Recommendation Report for Planning Permission

REF NO: WA/30/20/PL

LOCATION: Spindlewood
Yapton Lane
Walberton
BN18 0AS

PROPOSAL: Demolition of existing dwelling & erection of 8 No. dwellings with associated landscaping, parking & works. This application is a Departure from the Development Plan.

Drawing.
Site Plan

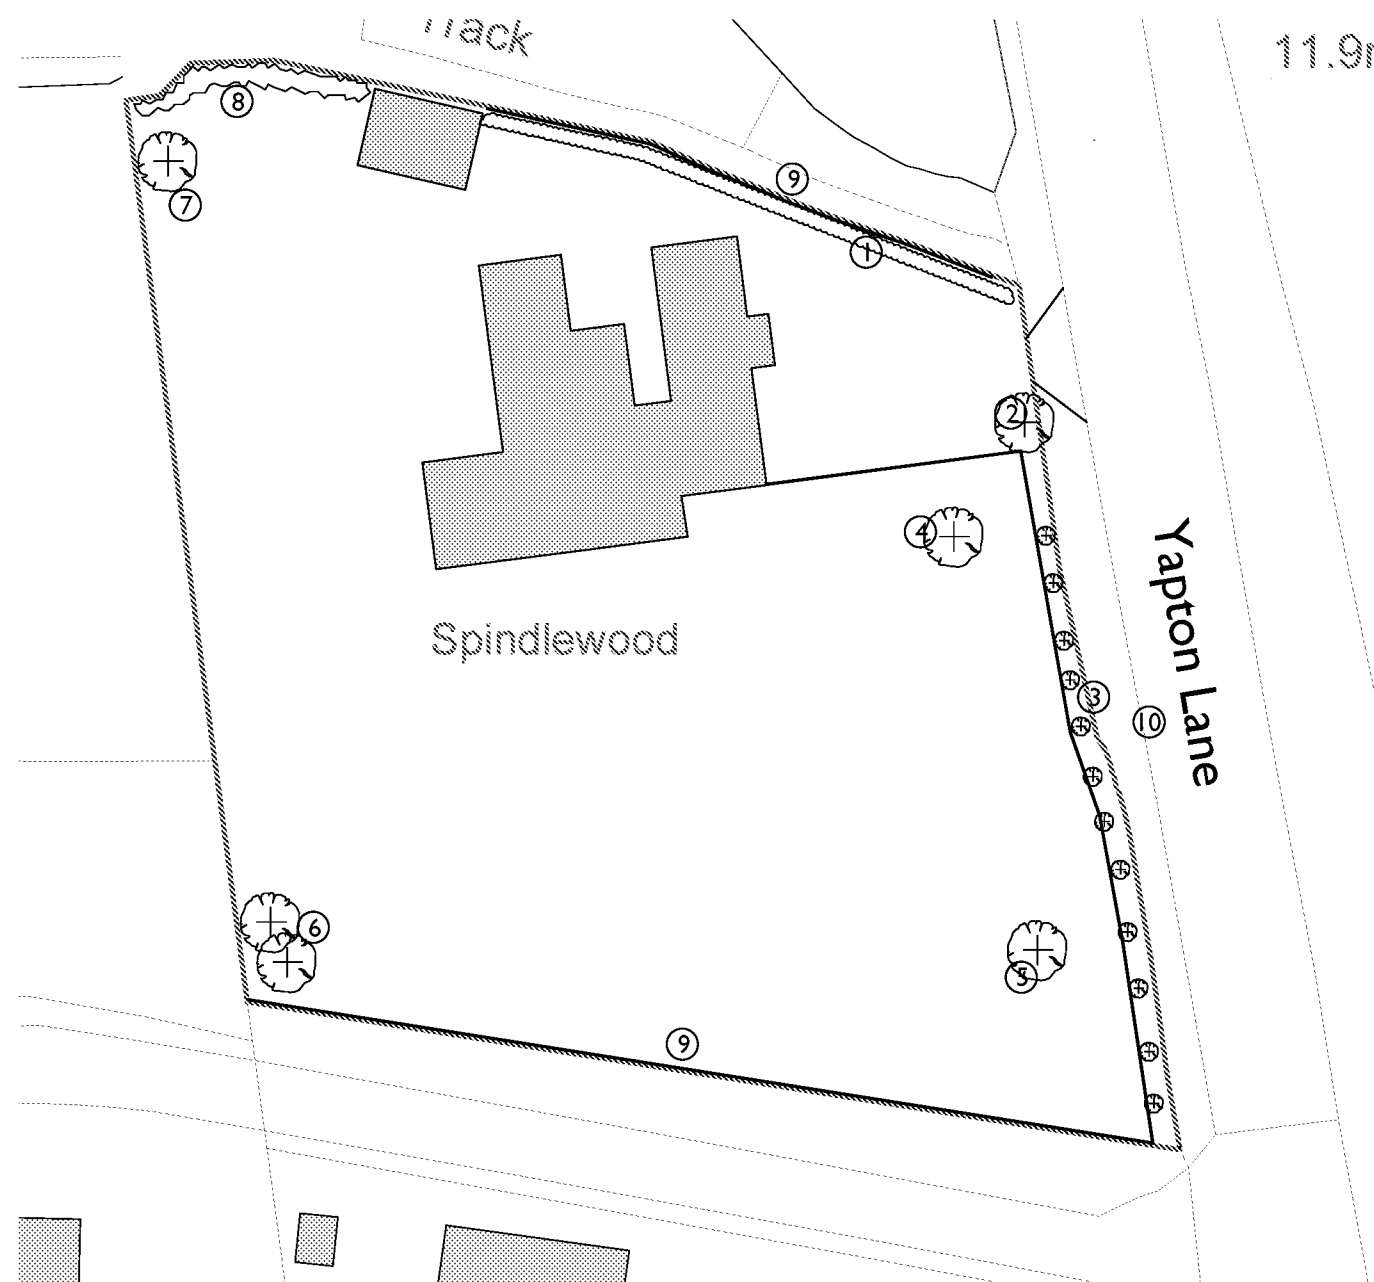
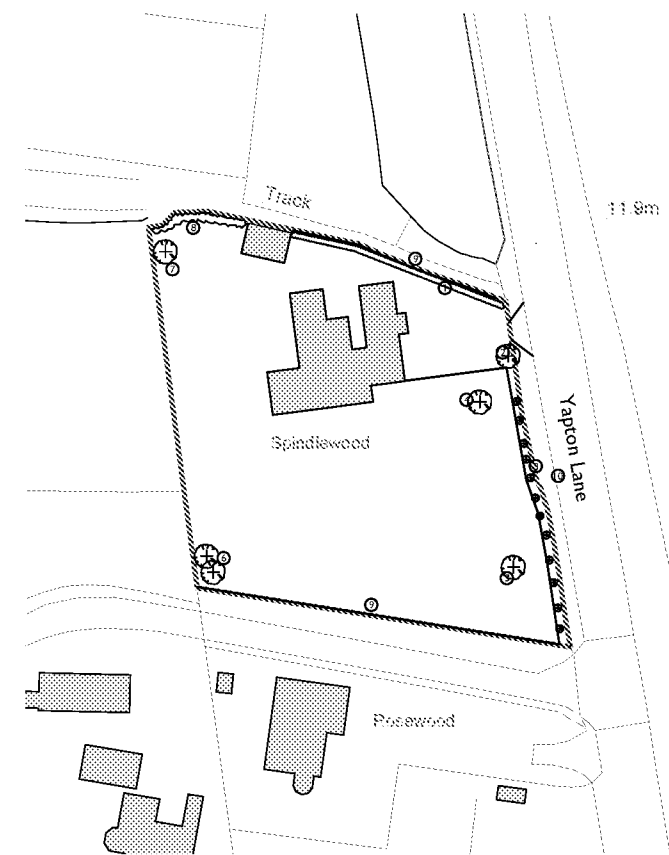
Concern has been raised by the Council's tree officer that the site has not been properly surveyed for trees and without such a survey he cannot comment on the acceptability of the proposal in regards to impact on trees. The application does not provide a tree survey to indicate that the development proposal will not lead to the loss of valuable trees. As a result the proposal is unacceptable on tree grounds and policy ENV DM4 of the ALP and policy VE3 of the Walberton Neighbourhood Development Plan.

- 3 The proposal is not accompanied by an accurate tree survey and may therefore result in the loss of tree/trees important in the local landscape that could be made subject to a Tree Preservation Order. The proposal would therefore be contrary to policy ENV DM4 of the Arun Local Plan and policy VE3 of the Walberton Neighbourhood Development Plan.

Drawing.
Proposed Barn
1, 2, 3 and 4 Plan

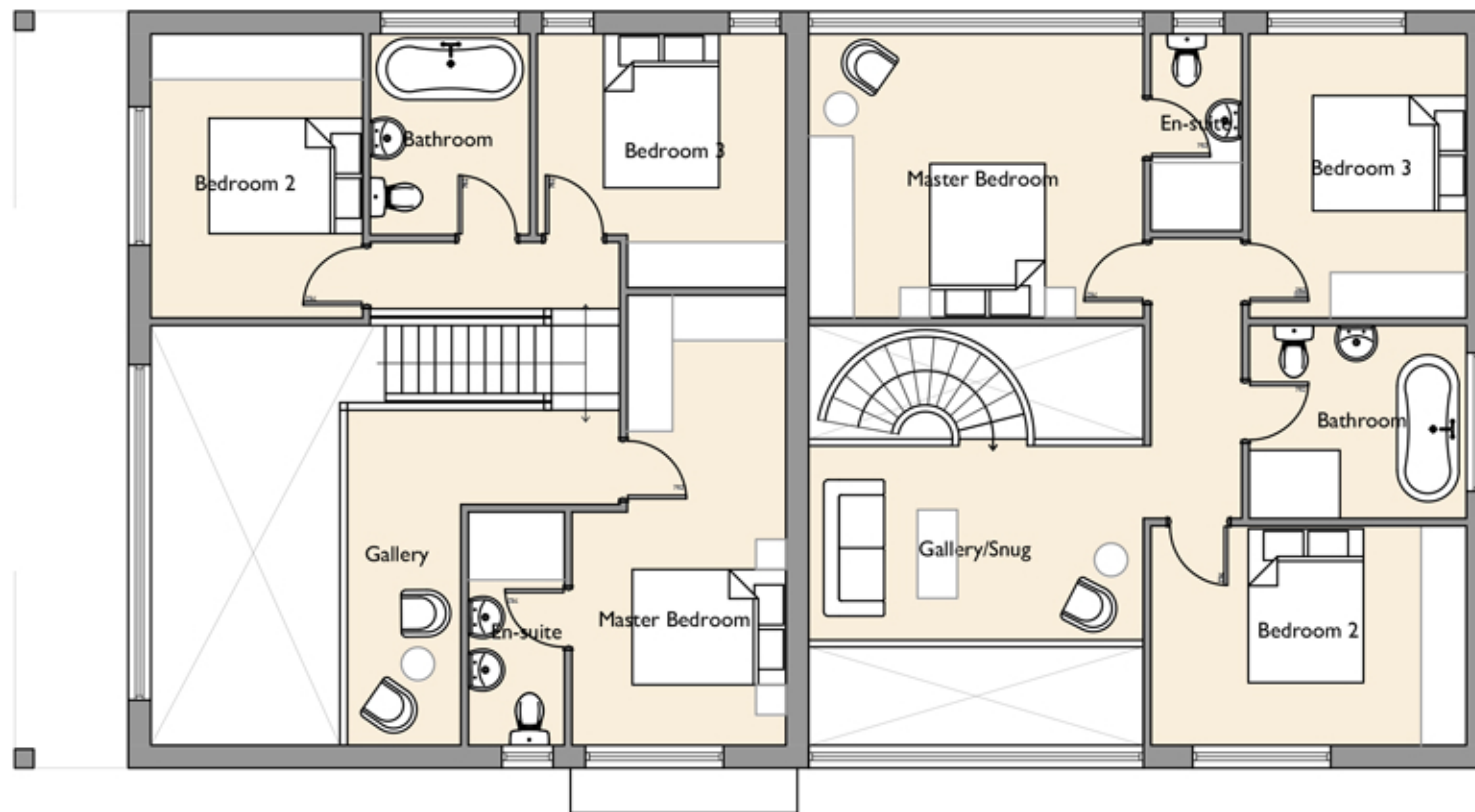
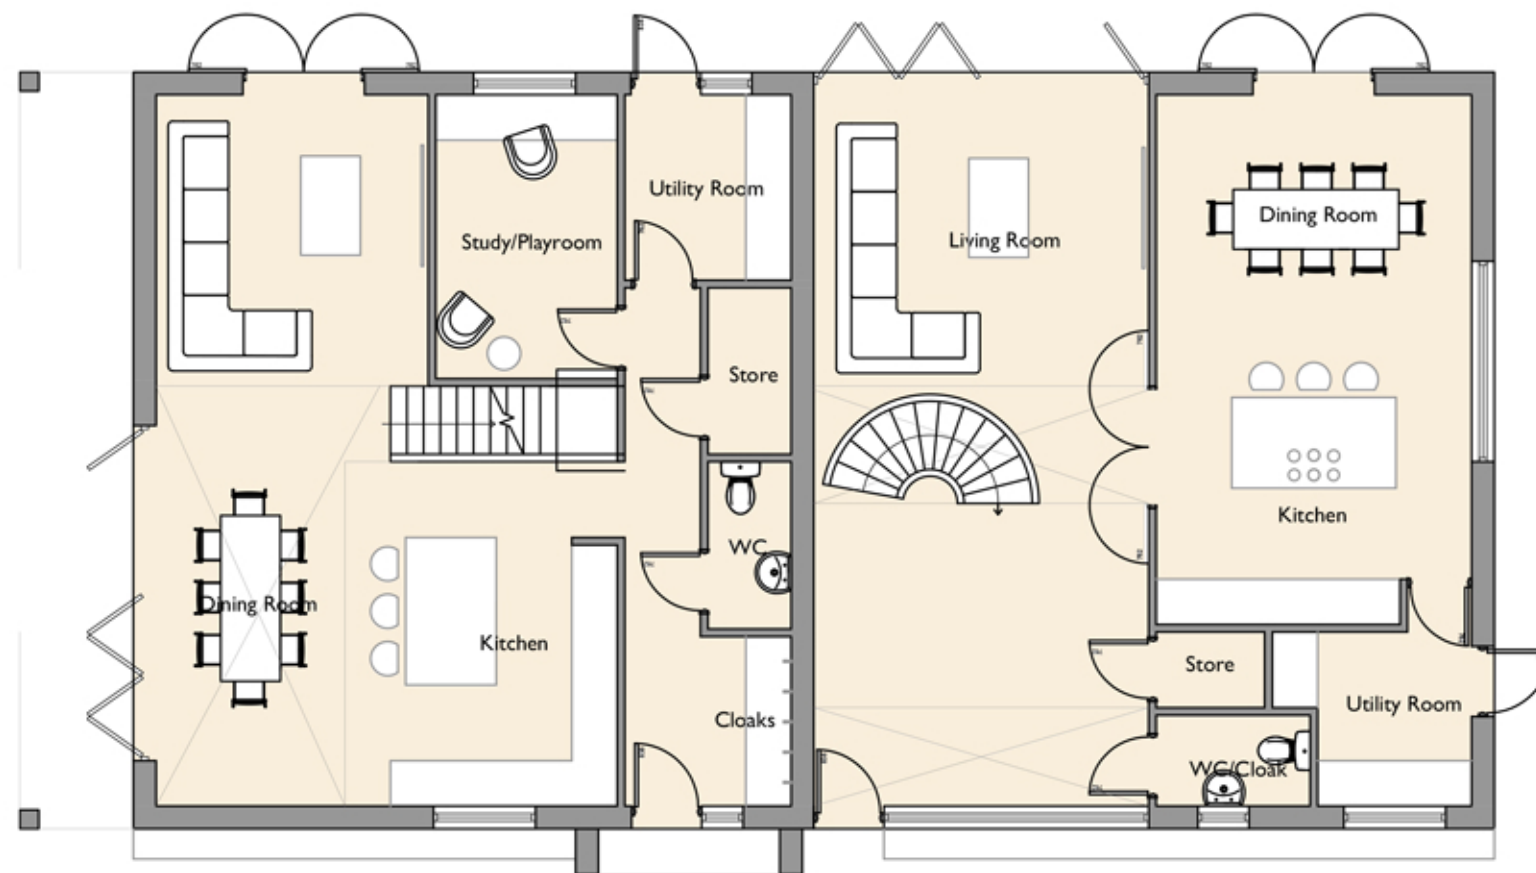
There are two house types proposed, cottage and barn. The barn house type would form two semi detached dwellings which would have an unacceptable relationship to each other in that the south elevation gable end of barn (dwelling no.2) would have primary full length windows within 6 metres of the gable end of the other barn semi detached property (Dwelling no.3) resulting in an unacceptable loss of light and overbearing impact on those windows. The windows would overlook the side garden of dwelling barn no.3.

cause unacceptable overlooking and an overbearing impact on those windows. The windows on the south elevation gable end of barn no.2 would also overlook the rear garden of barn no.3 causing an unacceptable loss of privacy on the use of that garden contrary to policies D DM1 and QE SP1 of the Arun Local Plan.

Drawing.
Proposed Site Plan

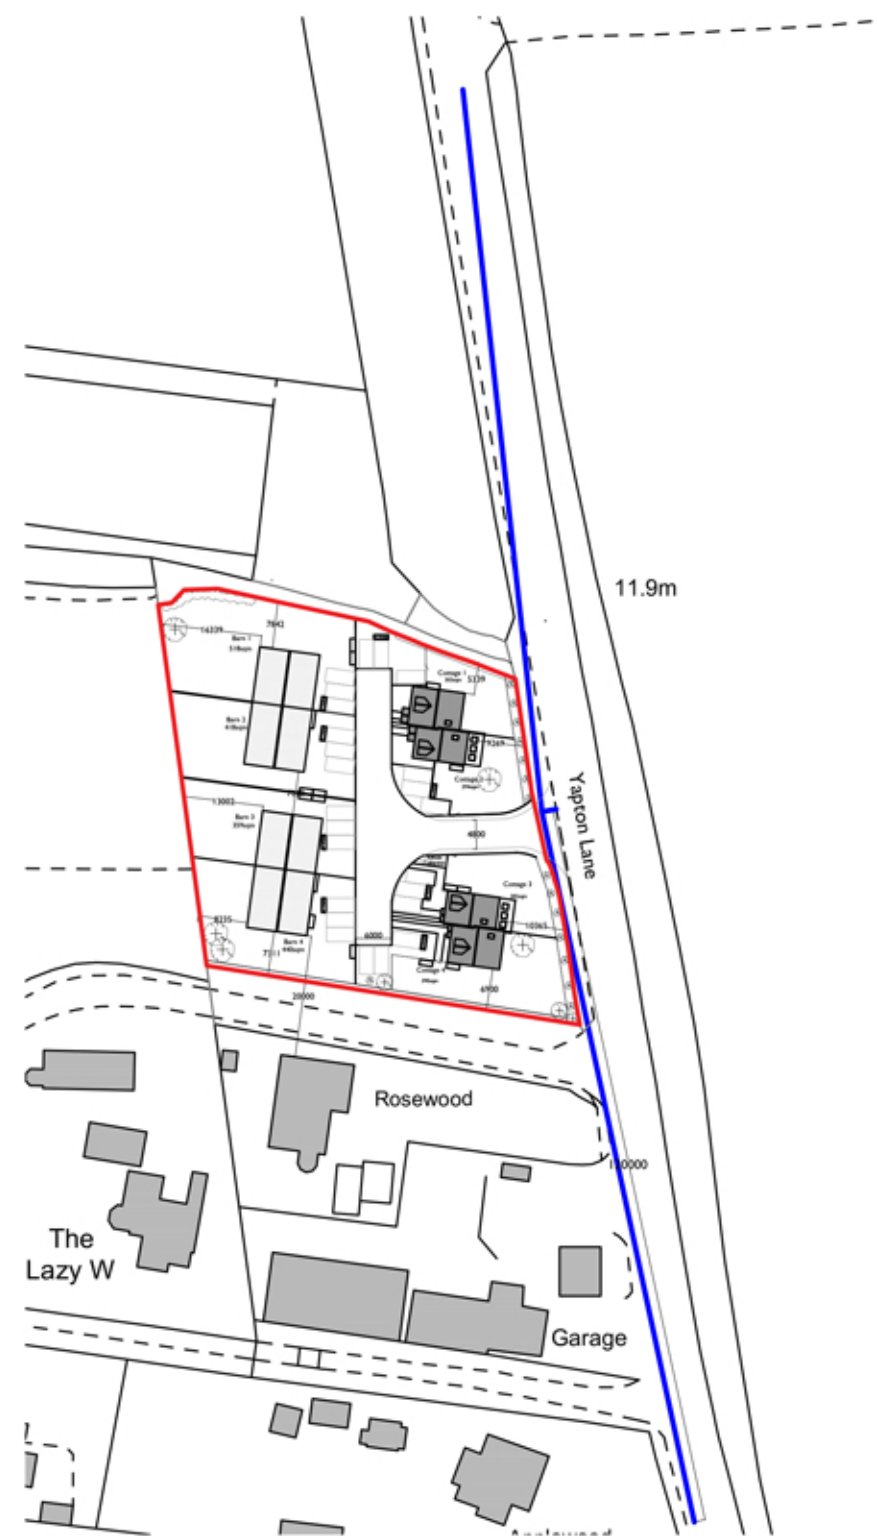
The existing character of this section of Yapton Lane is derived from sporadically located, ribbon like pattern of single dwellings fronting Yapton Lane. These are interspersed with plant nurseries. The amount/density of development on the site and the orientation and layout of the proposed development would not accord with the general pattern of development along Yapton Lane. The proposal would therefore result in the character of the area being unacceptably affected.

The amount/density of development on the site and the orientation and layout of the proposed development would not accord with the general pattern of development along Yapton Lane. The proposal would therefore result in the character and appearance of the area being unacceptably affected contrary to policies D DM1, D SP1 and QE SP1 of the Arun Local Plan and policies HP11 & HP13 of the Walberton Neighbourhood Plan.
- 2 The south elevation gable end of barn no.2 would have primary full length windows within 6 metres of the north gable end windows of barn no.3 which, at such close proximity, would
